**Addendum No. 1**

RE: Contract ID: C201397  
WBS# 37460  
Hyde County  
NC-45 From US-264  
To Beaufort County Line.

**August 15, 2006 Letting**

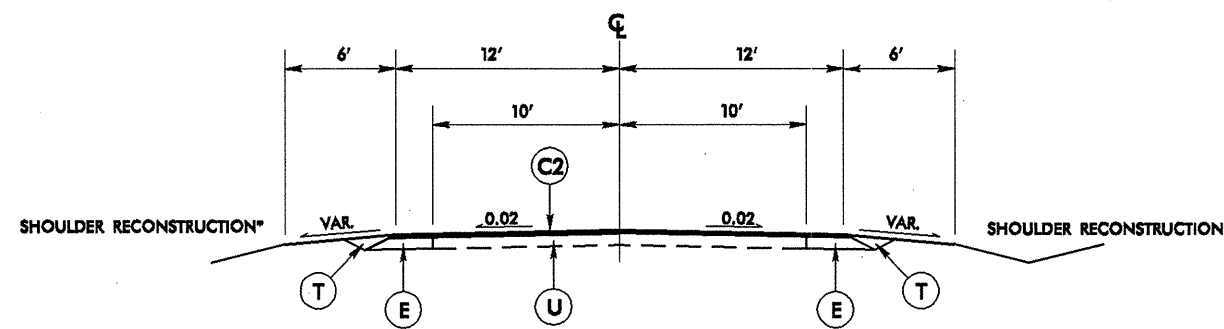
On sheet No. 2, Note No. 7 has been revised. Please void Sheet No. 2 in your sketch maps and staple the revised Sheet No. 2 thereto.
